**From:** Rich Elliott <elliott@kvfr.org>  
**Sent:** Thursday, February 21, 2013 4:52 PM  
**To:** Jeff Watson; Dan Valoff  
**Subject:** RE: Kittitas County Notice of Application

[AU-13-00001 Thayer](#)

**Administrative Use Permit (Accessory Dwelling Unit)**

Thayer ADU Permit  
 Site Map  
 2421 Judge Ronald Road  
 Ellensburg WA 98926

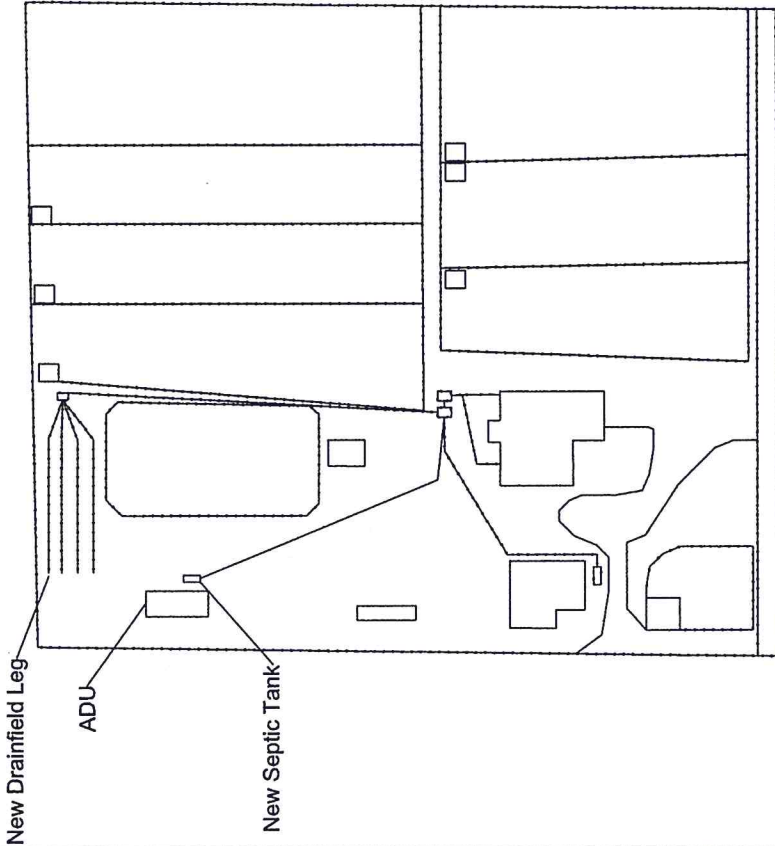
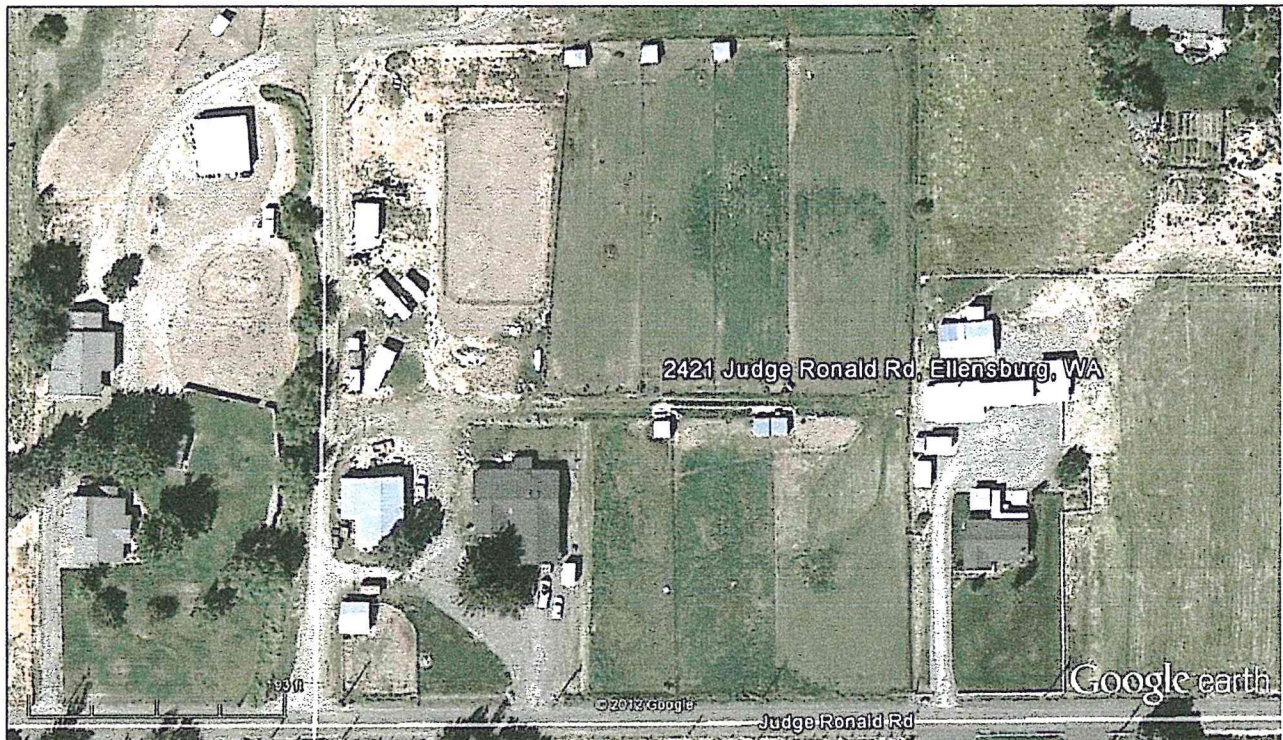
1. The ADU should be clearly addressed from both directions of travel as well as from the property itself.
2. Access to all residential structures should comply with Appendix D of the current version of the IFC when construction permits are issued.
